November 14, 2023

Re: Dutch Bros. Coffee
2501 Juan Tabo Blvd. NE
30-Day Temporary Certificate of Occupancy
Transportation Development Final Inspection
Engineer's Stamp dated 11-17-22 (H21-D004B)
Certification dated 11-07-23

From: Cherne, Curtis
Sent: Wednesday, November 15, 2023 10:23 AM
To: Genny Donart (gennyd@iacivil.com); Fred Arfman (freda@iacivil.com)
Cc: Al-najjar, Marwa G.
Subject: Dutch Brothers-2501 Juan Tabo- slept on it- revised condition for Perm CO

CP-401

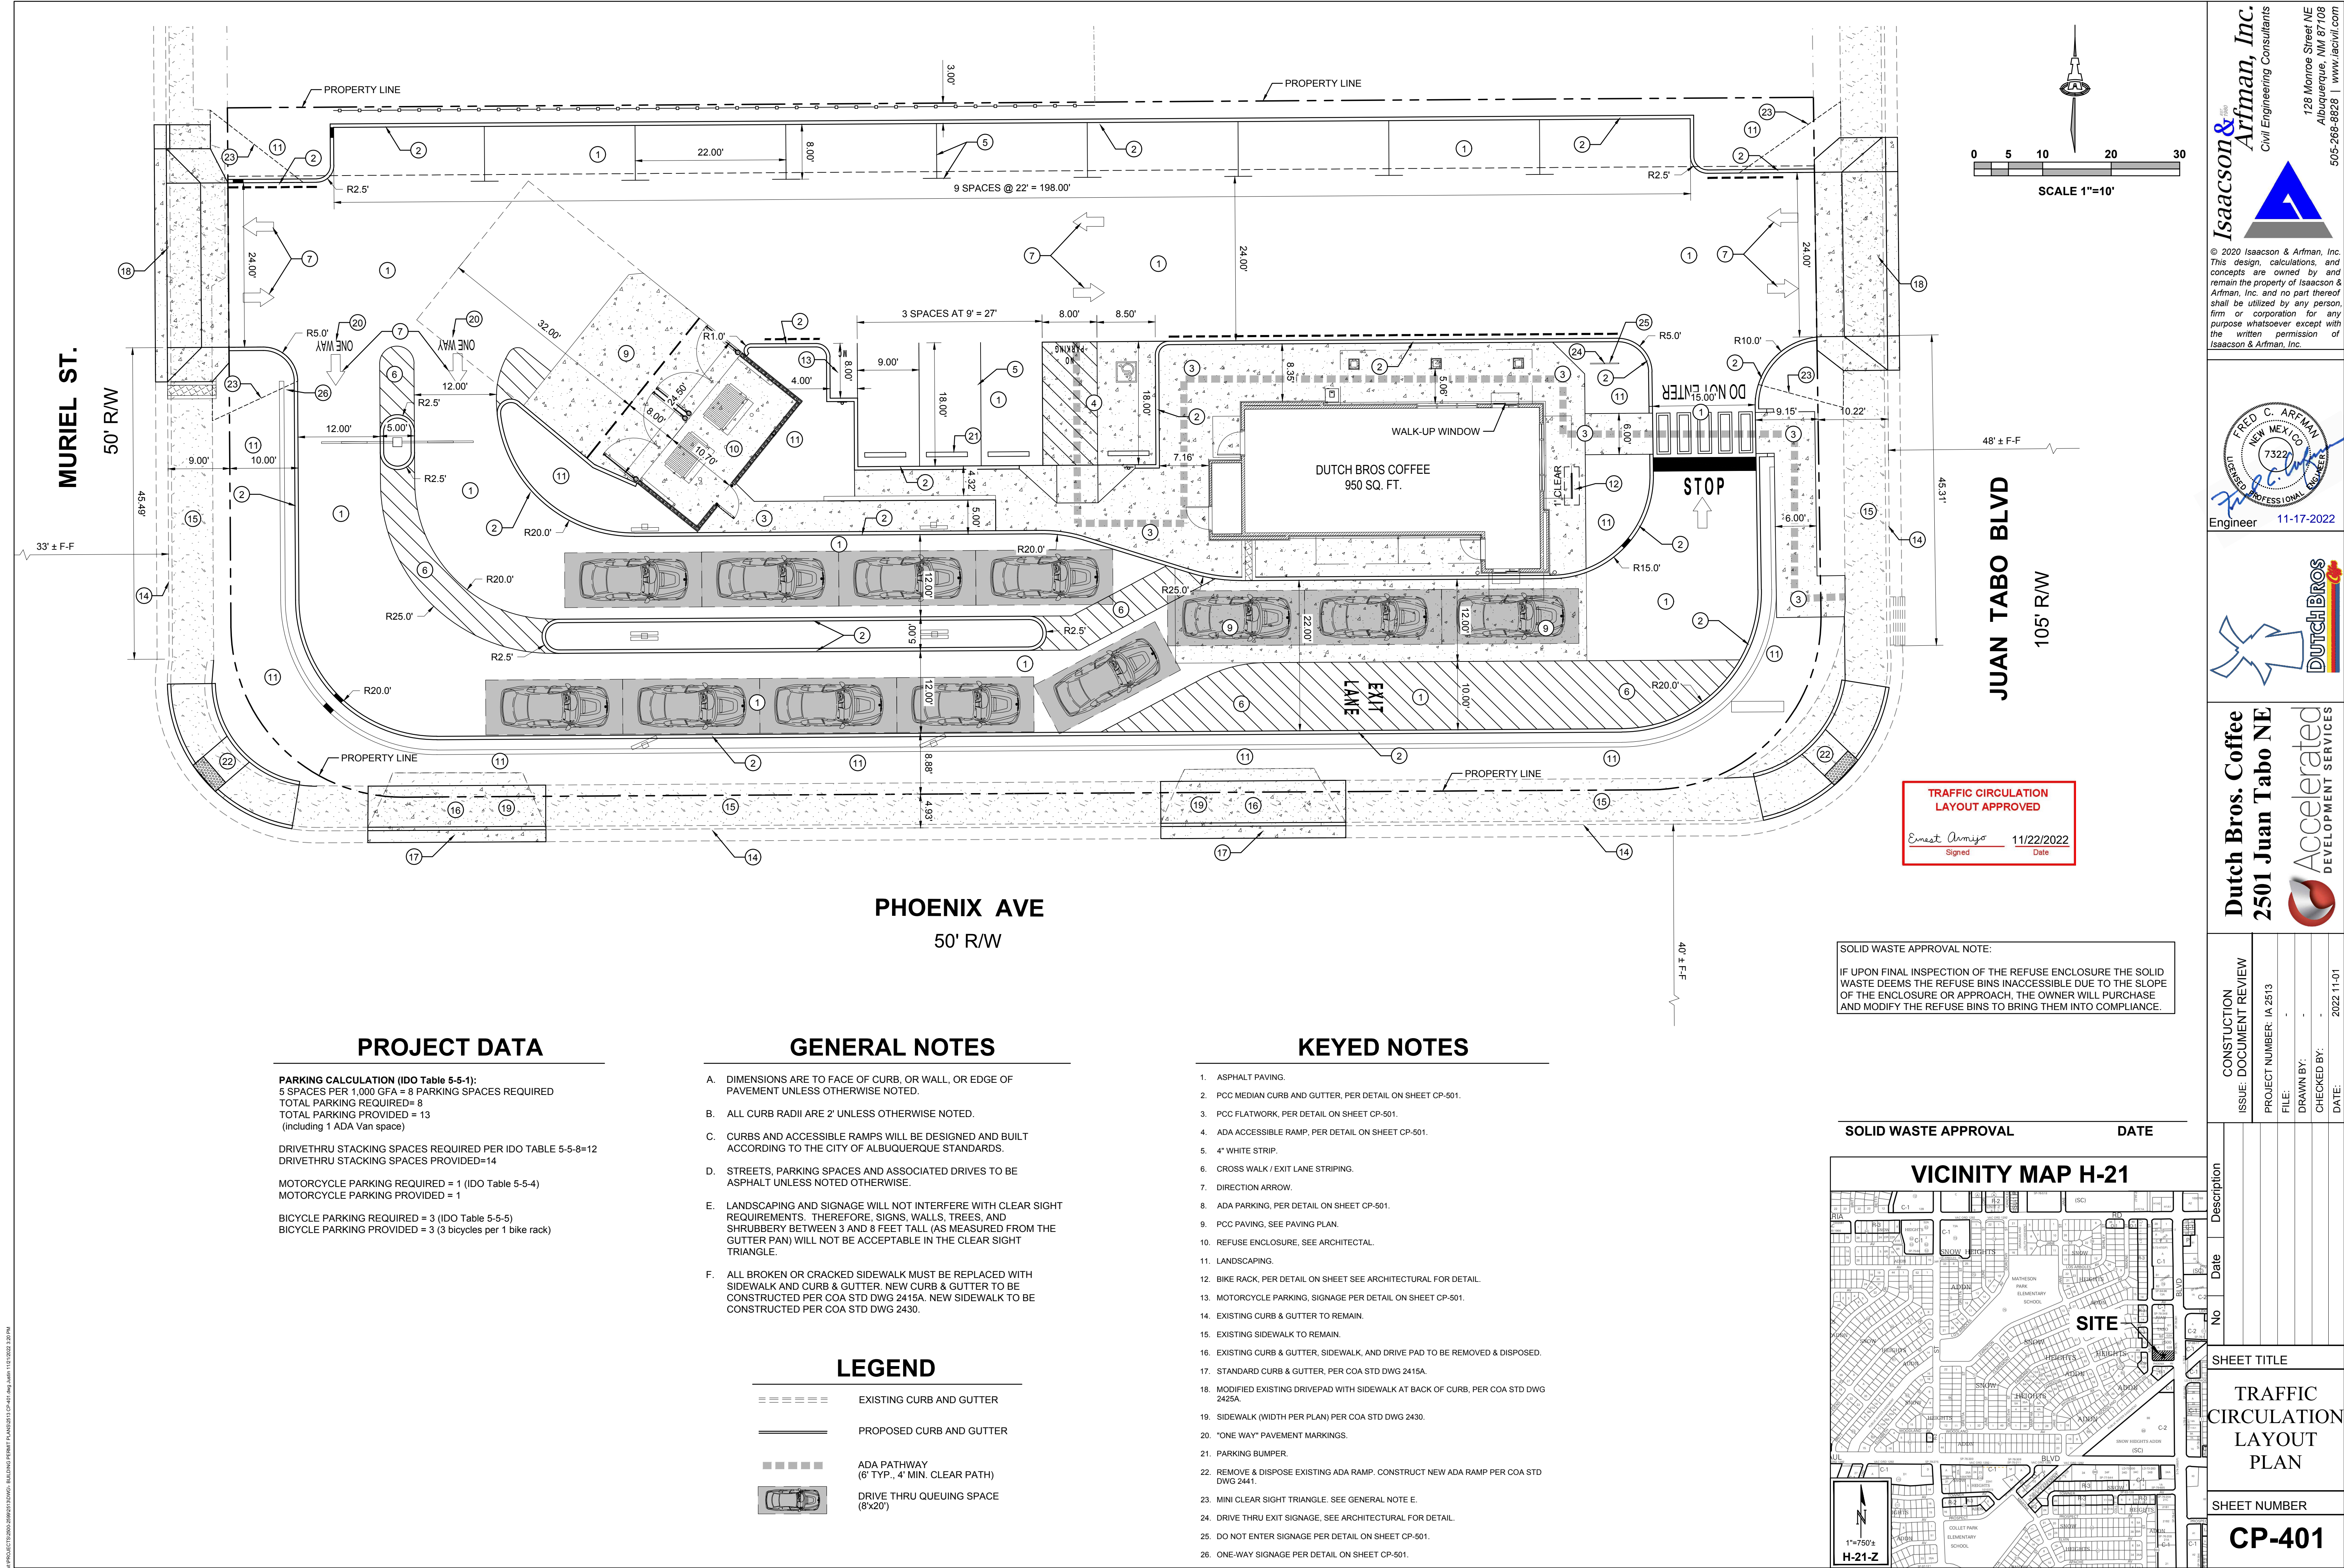
- Site access off Juan Tabo Blvd: Per city std the pedestrian pathway should be minimum 4 ft. wide. Per site visit the pathway was only 3 ft. wide. Please provide 4 ft. pathway.

- Per site visit, the new sidewalk off Phoenix Ave. has a cross slope range between 2.8% and 3.4%. Please note that maximum allowable cross slope should be 2%.

The deleted item is the sidewalk on Phoenix.

Please accept this email as a revision to the letter. This has been discussed with Marwa Al-najjar.
